Kirklees Direct
Tel: 01484 414746
Email: alice.downham@kirklees.gov.ukIlyas Ramjan,
ISR Design Consultancy
4, Millwater Avenue
Thornhill Lees
Dewsbury
WF12 9QNDate: 25-May-2021
Our Ref: 2021/91524

TOWN AND COUNTRY PLANNING ACT 1990
TOWN AND COUNTRY PLANNING (GENERAL PERMITTED DEVELOPMENT) (ENGLAND)
ORDER 2015 – SCHEDULE 2, PART 1, CLASS A.1 (g)
AT: 60, Bennett Lane, Dewsbury, WF12 7DY
Prior notification for single storey rear extension

Date: Apr 2021		Project: New Rear Extension 60 Bennett Lane, Dewsbury		Drawing Title: Block Plan		Drawing No: SK02		Rev	
						Scale: 1:200		Paper Size: A4

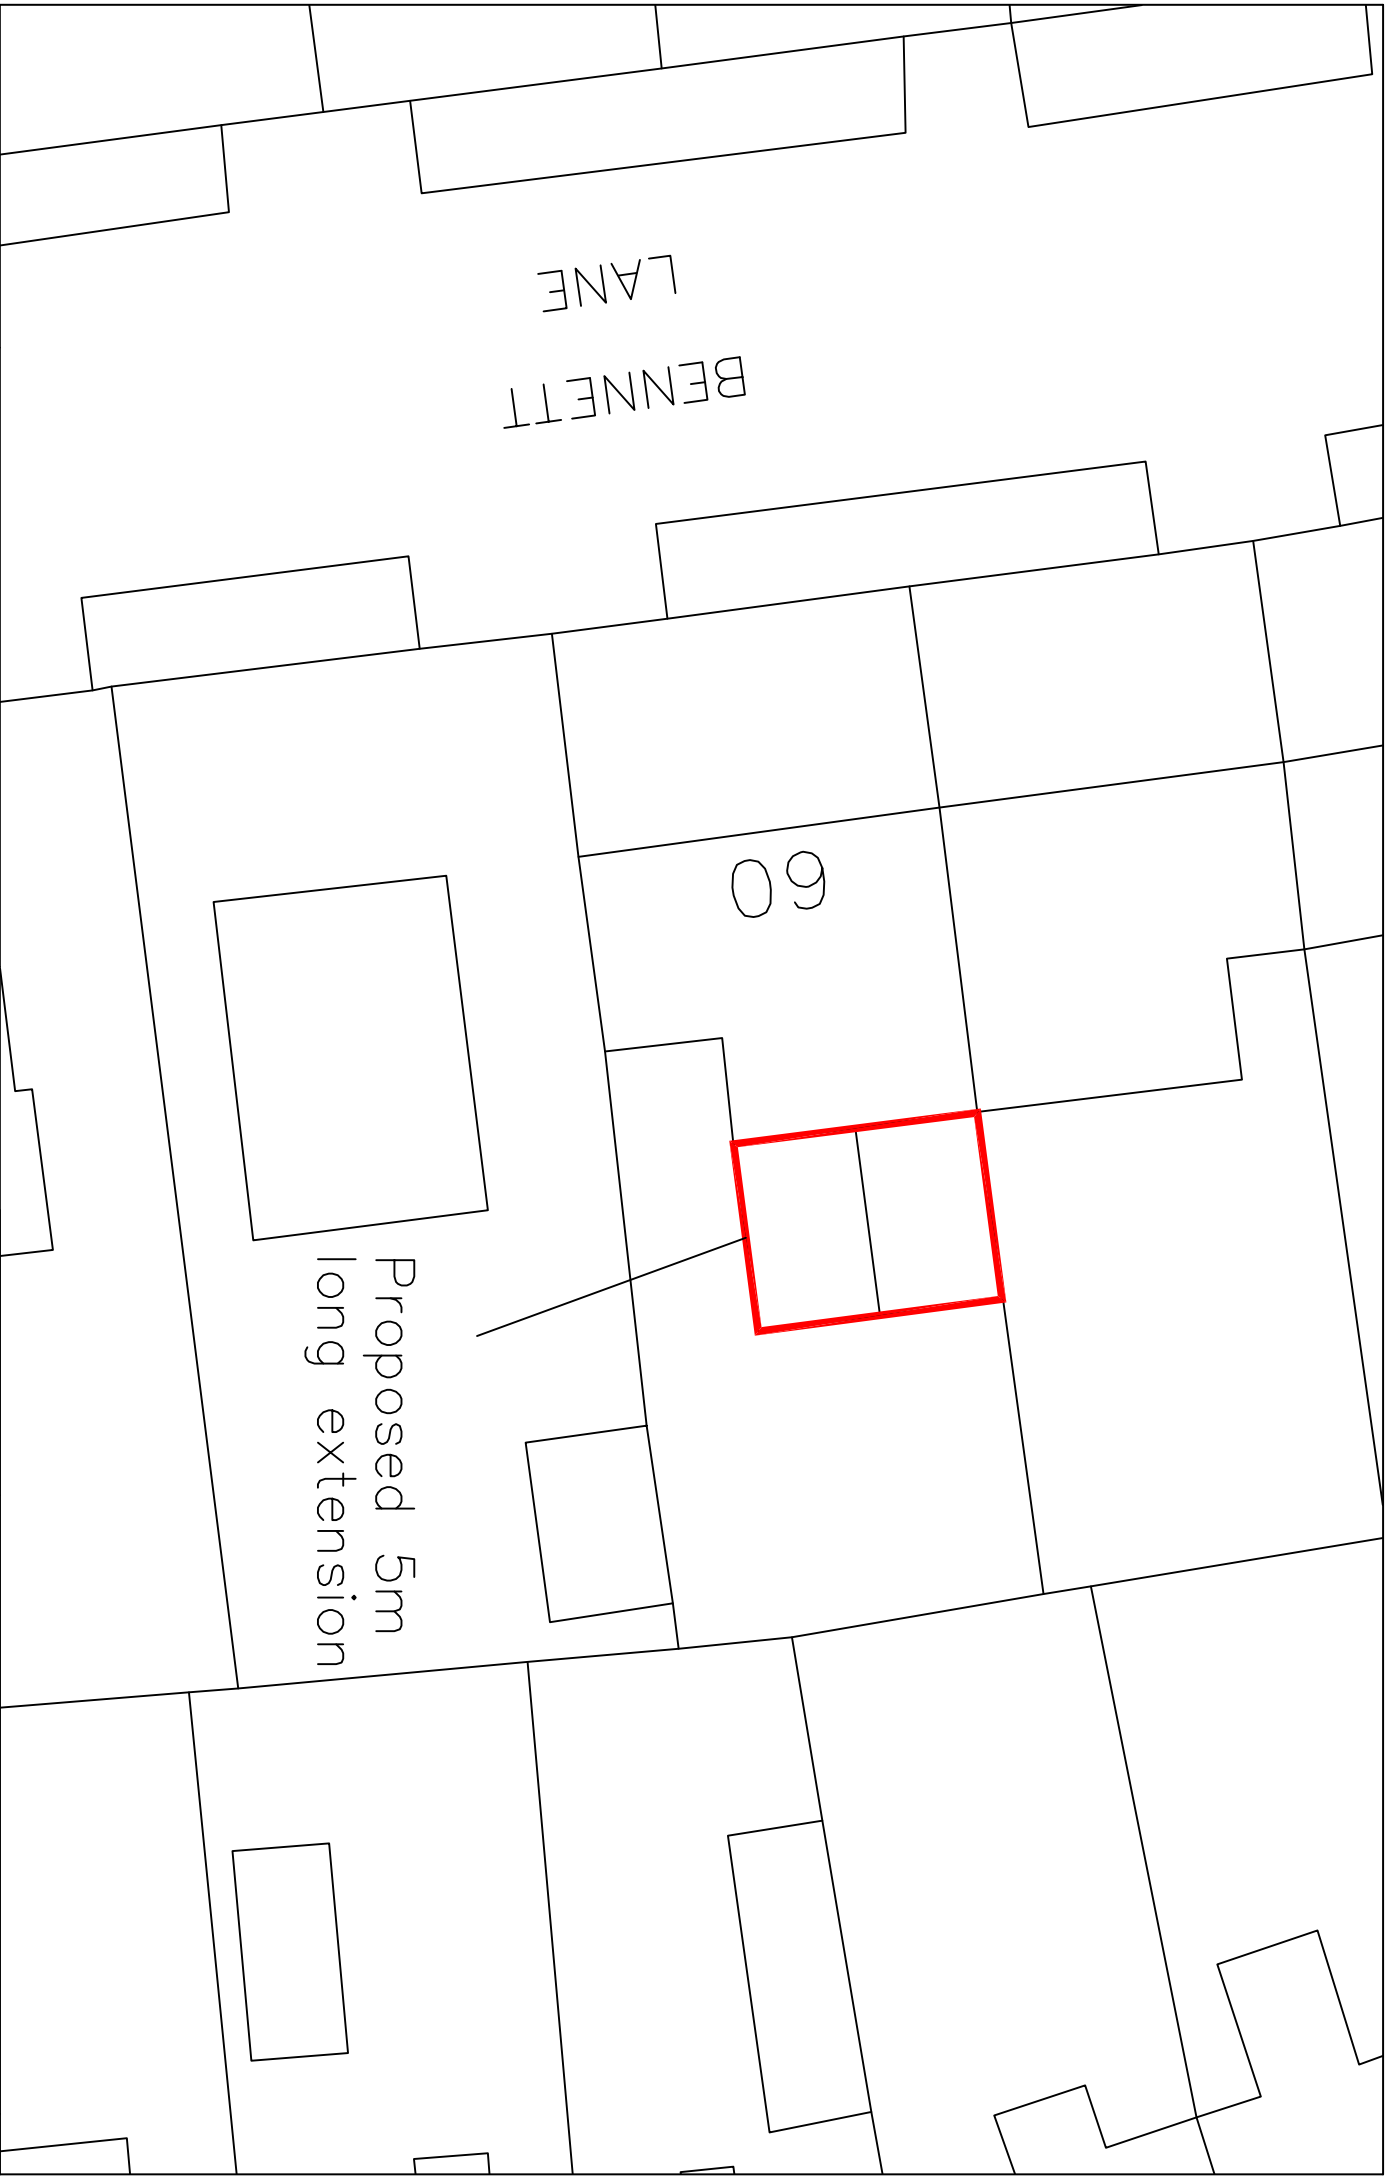
By reason of the location of the proposed extension, which would be located within two metres of the boundary and which would have an eaves height of more than three metres, the proposed extension exceeds the criterion as stated in paragraph A.1 (i) of Class A and therefore cannot be considered to benefit from a general planning permission by virtue of Part 1, Class A of Schedule 2 of the Town and Country Planning (General Permitted Development)(England) Order 2015 (as amended).
